# **OXFORDSHIRE COUNTY COUNCIL'S RESPONSE TO CONSULTATION ON THE FOLLOWING DEVELOPMENT PROPOSAL**

**Application No:** 17/00983/REM

**Proposal:** Reserved matters application to 10/01642/OUT - In respect of Bovis Parcel B4A and B4B to provide 29 open market and 71 affordable dwellings

**Location:** Parcels B4A & B4B Heyford Park Camp Road Upper Heyford Bicester OX25 5HD

Project: Heyford Park - B4A/B4B Highways Plan. Drawn by: MCC/CCW/KM. Checked by: MCC. Date: 04/10/17. Scale: 1:500. Drawing No: B.0285\_117 REV A. Client: Bovis Homes. All rights reserved.

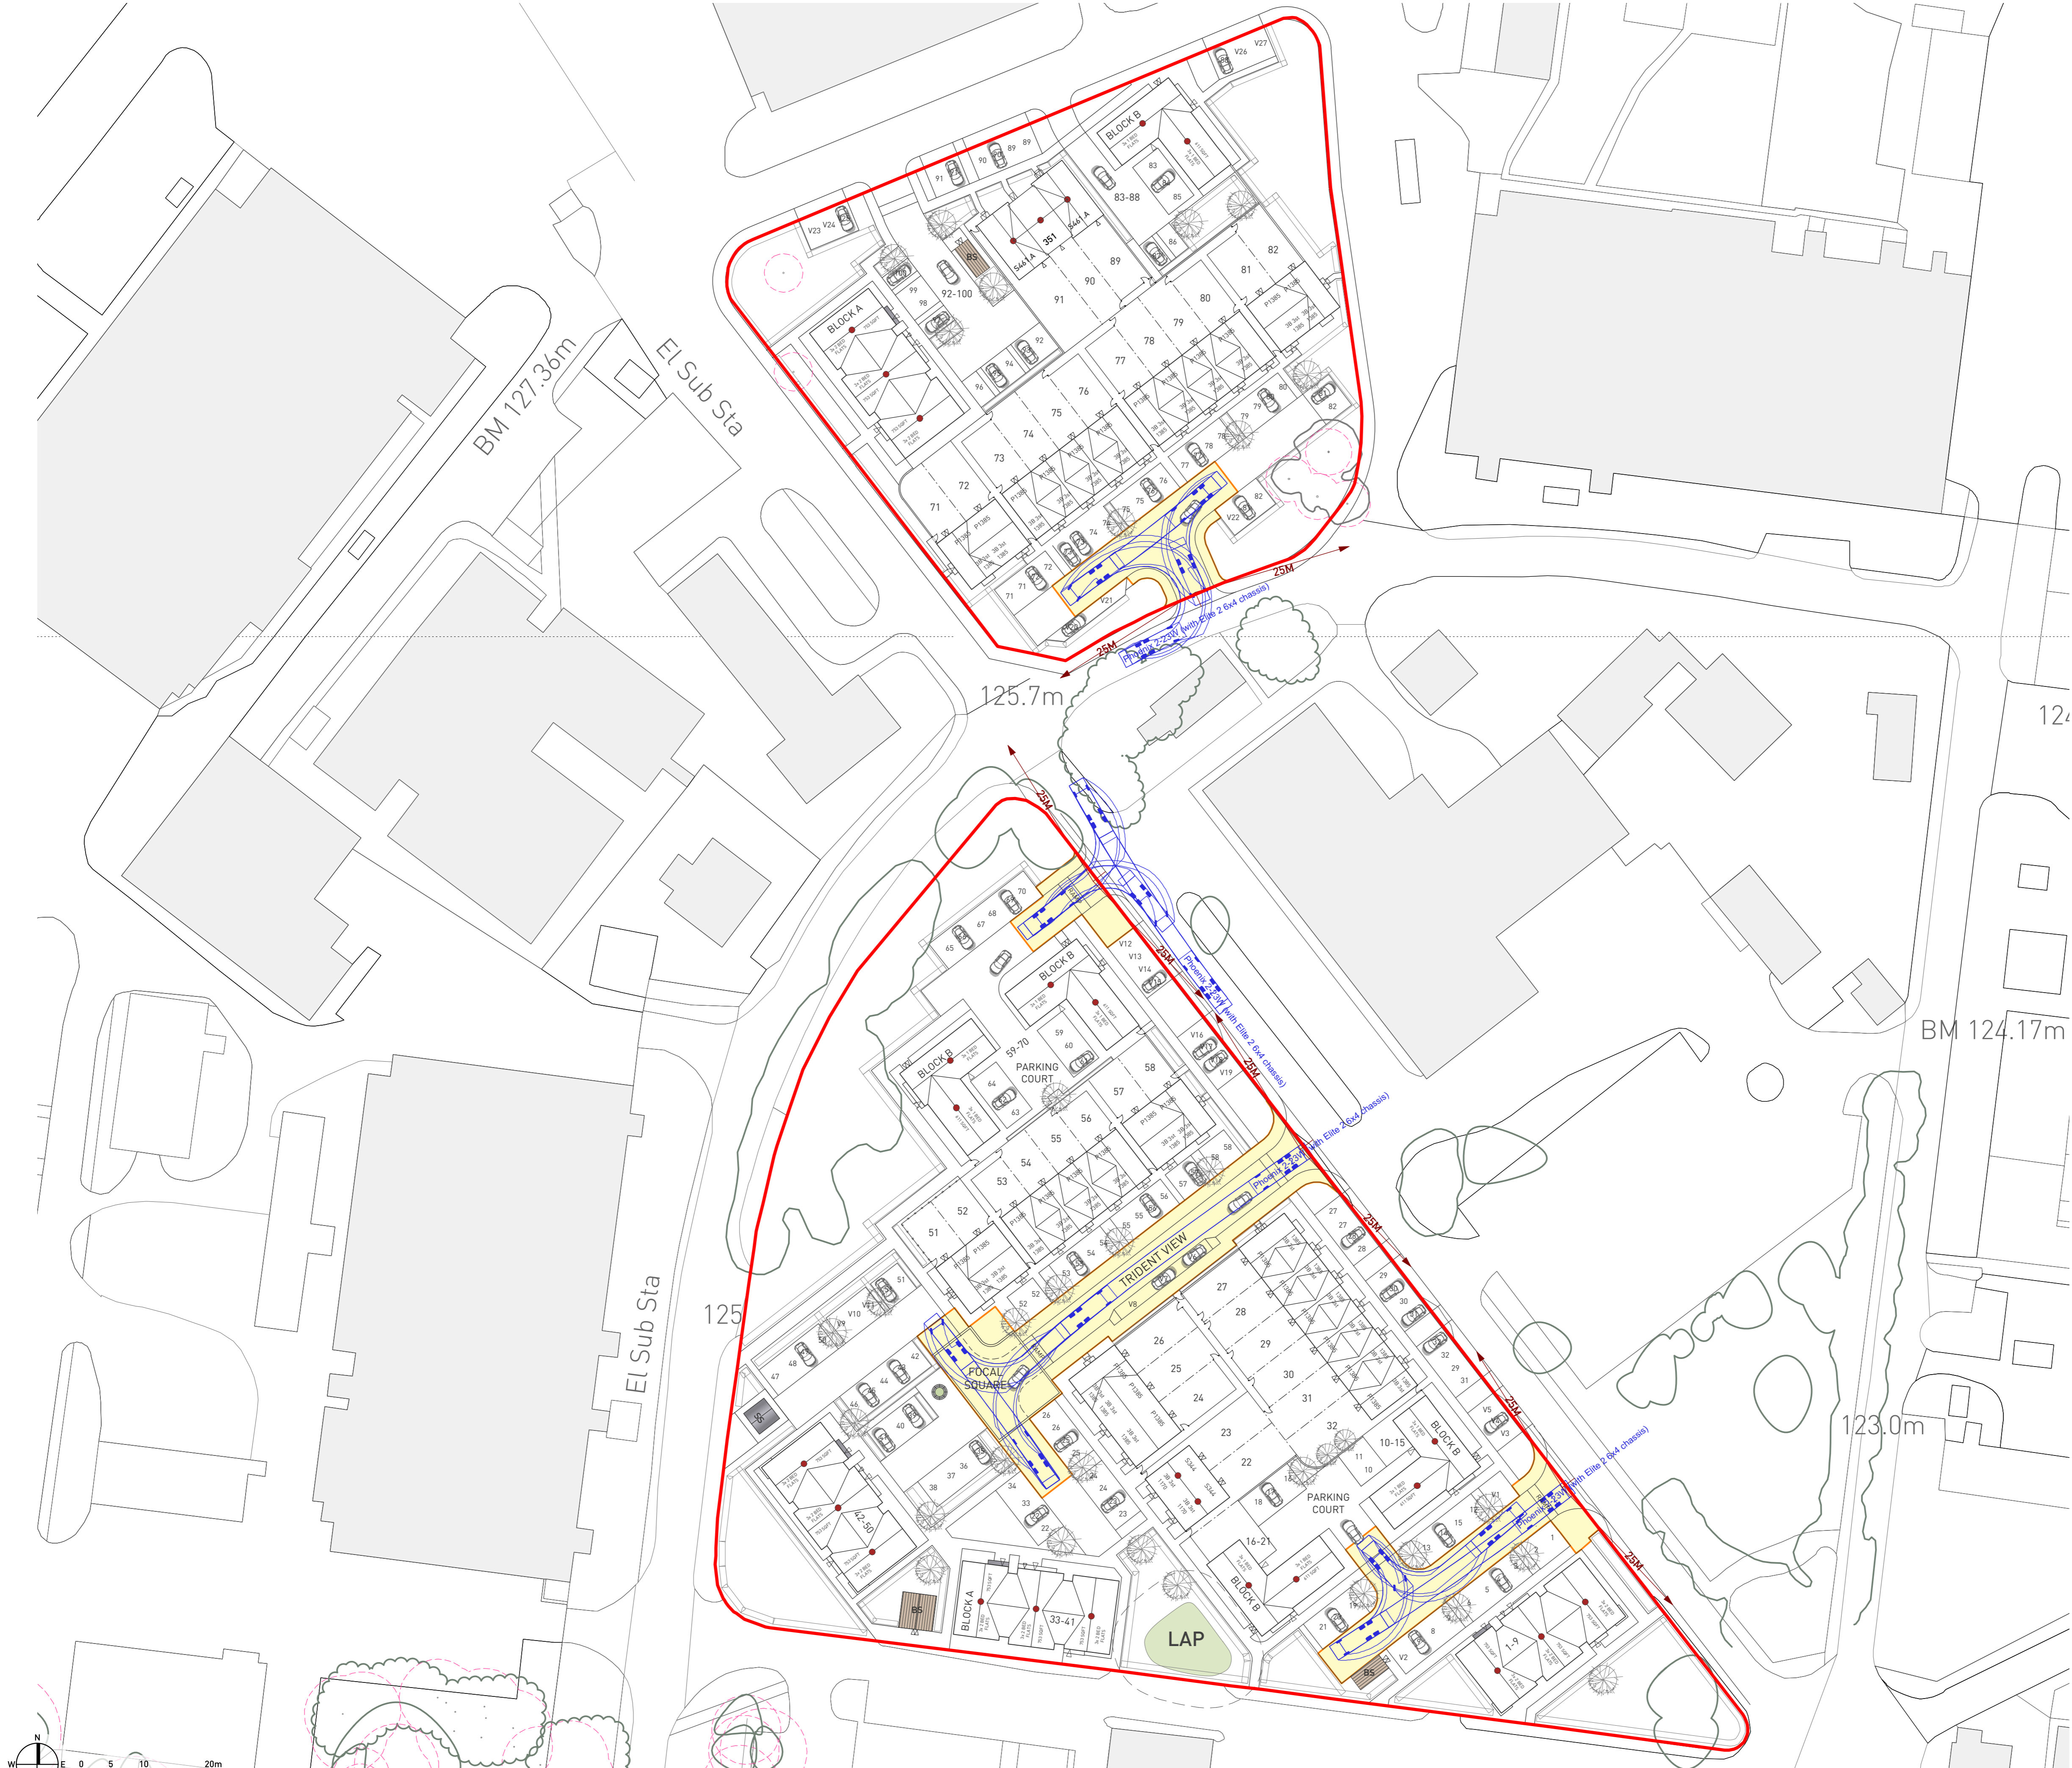
The adoptable highway shown on plan No.B.0285\_117 will need to be designed and constructed in accordance with the Heyford Park Design Code, and to the satisfaction of the County under a Section 38/278 agreement.

HEYFORD PARK - B4A/B4B TRIDENT PARKING STRATEGY

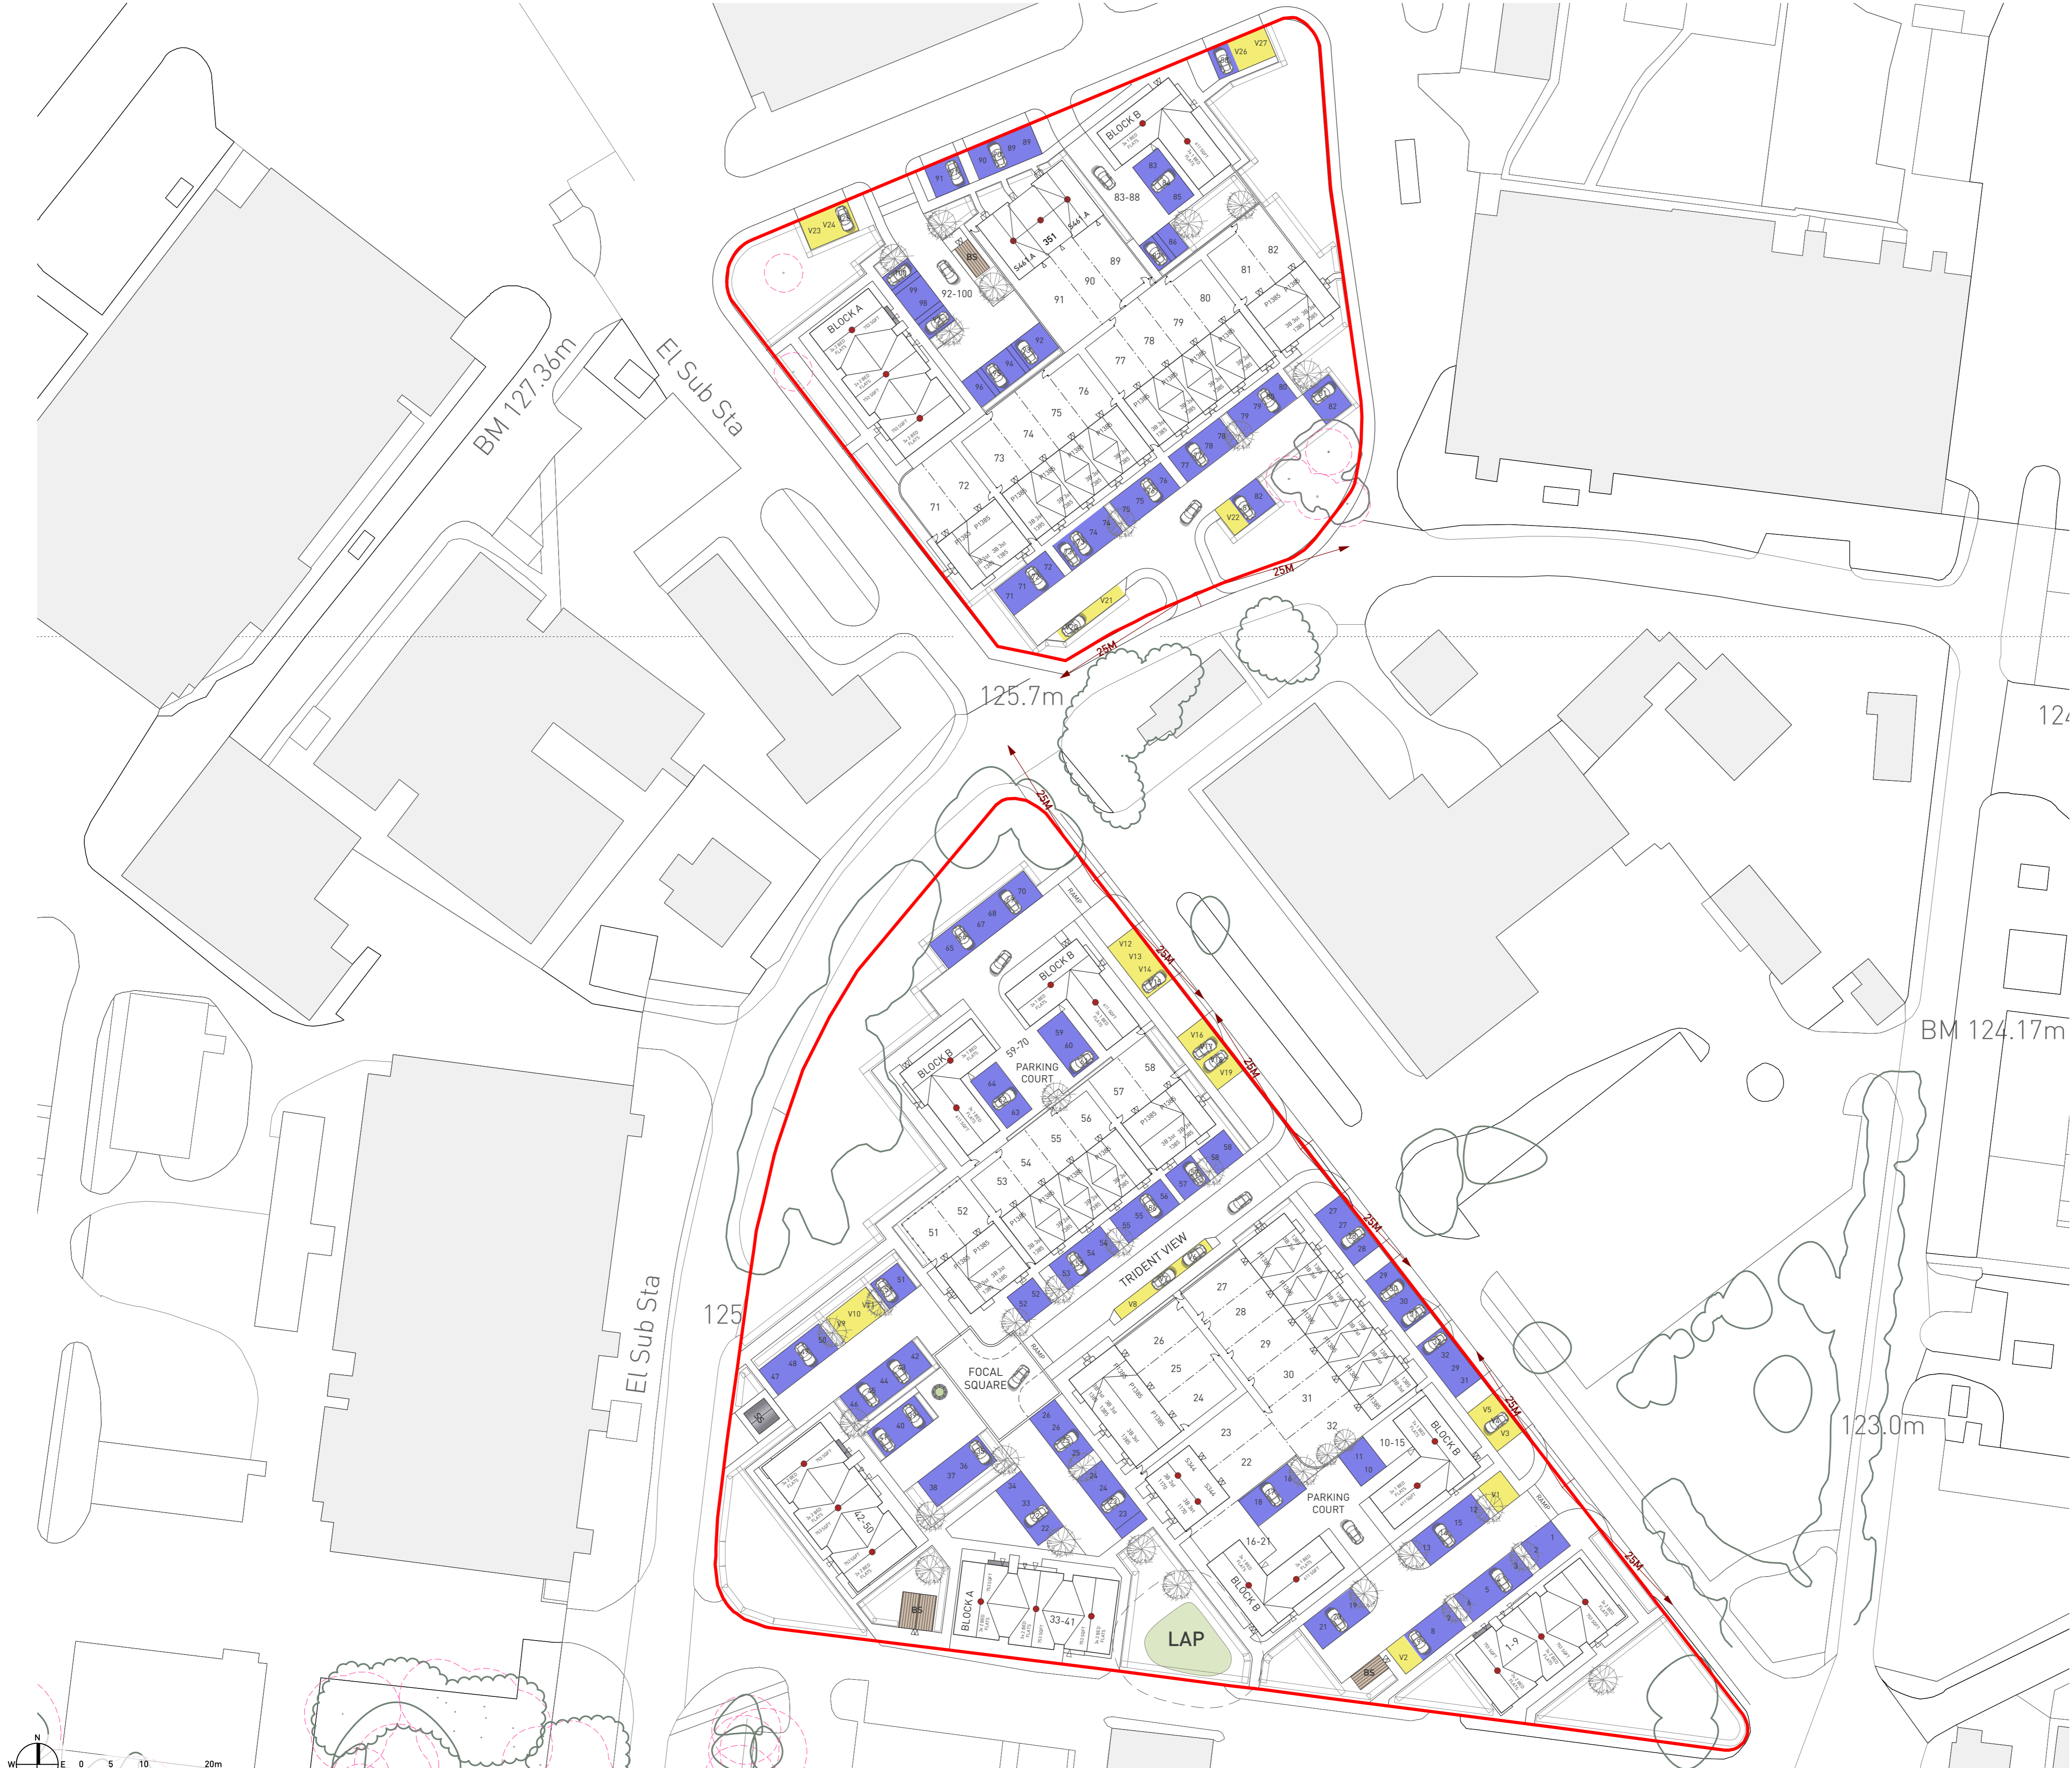
Parking provision meets the standards set out in the Heyford Park Design Code, however this is minimal and the level of provision is likely to lead to on-street parking and the use of visitor parking spaces by residents. Swept path analysis demonstrates that parking is accessible.
